Comments for Planning Application S/23/1069

Application Number: S/23/1069

Address: The Chalet Church Row Hinton Parva Swindon SN4 0DW

Proposal: Demolition of existing chalet, erection of 1no. dwelling (Class C3), retention of garage and ancillary accommodation and associated works.

Front Elevation

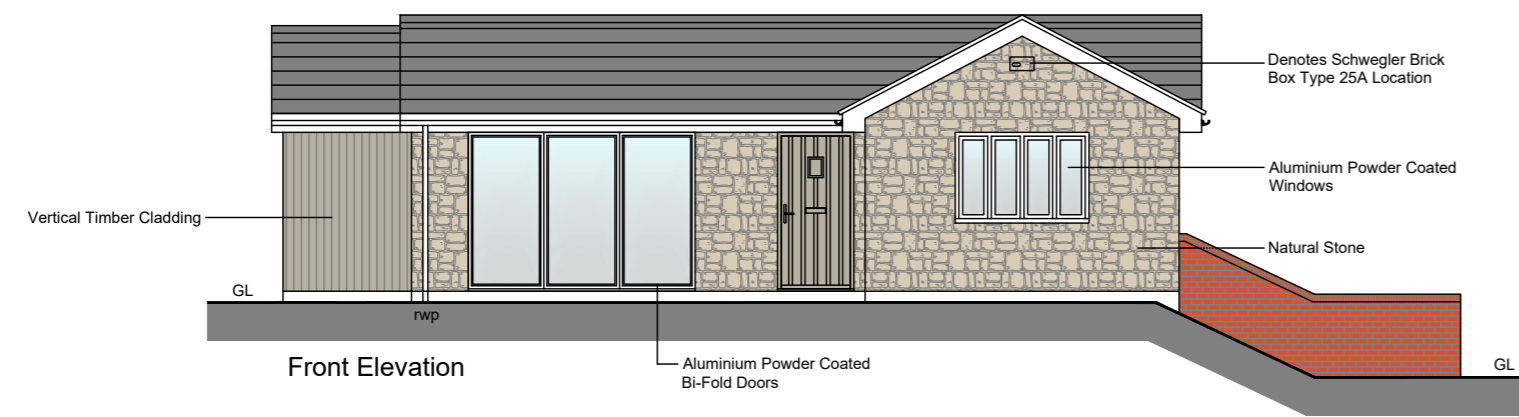
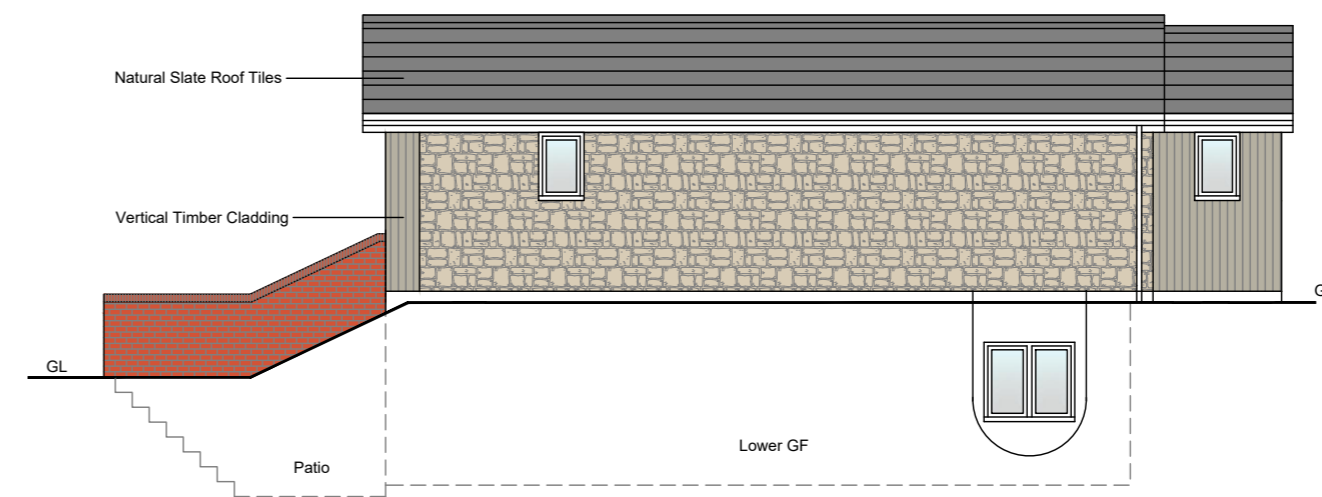
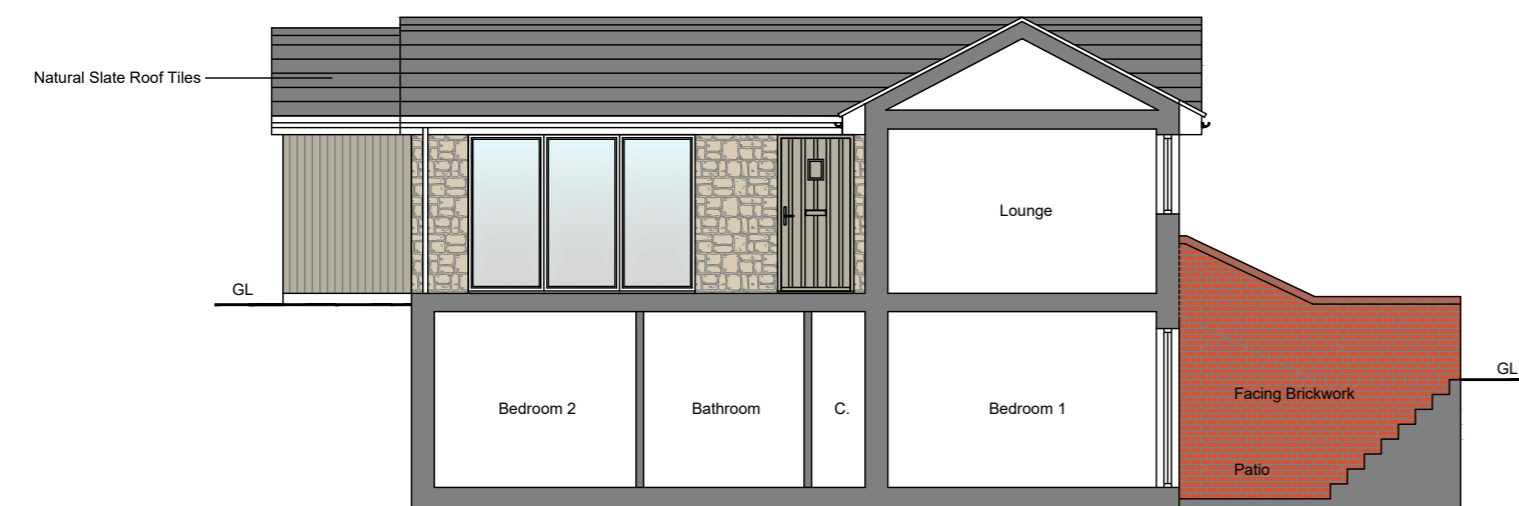
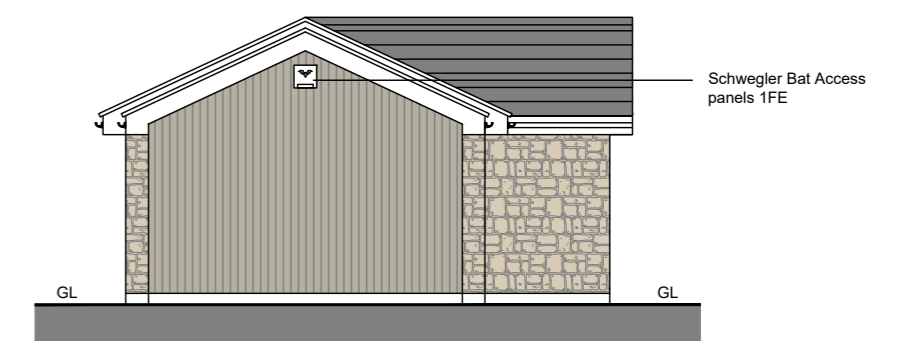
In addition, this revised planning application requests the elevation walling materials to be changed from horizontal timber boarding (as it is currently) to predominantly stone walling with some feature timber panelling. This is not in keeping with its surroundings and entirely unsuitable for its location in the historic centre of the village.

Under a previous planning application referenced S/19/0936 a similar change to brick and stone walling was refused as it was not in keeping and was deemed to be too fussy. Subsequent applications made reverted back to timber wall boarding which was the basis (in part) for the final granting of permission.

Consistency in the decision based on the material appearance must be made and this application should be refused on those grounds.
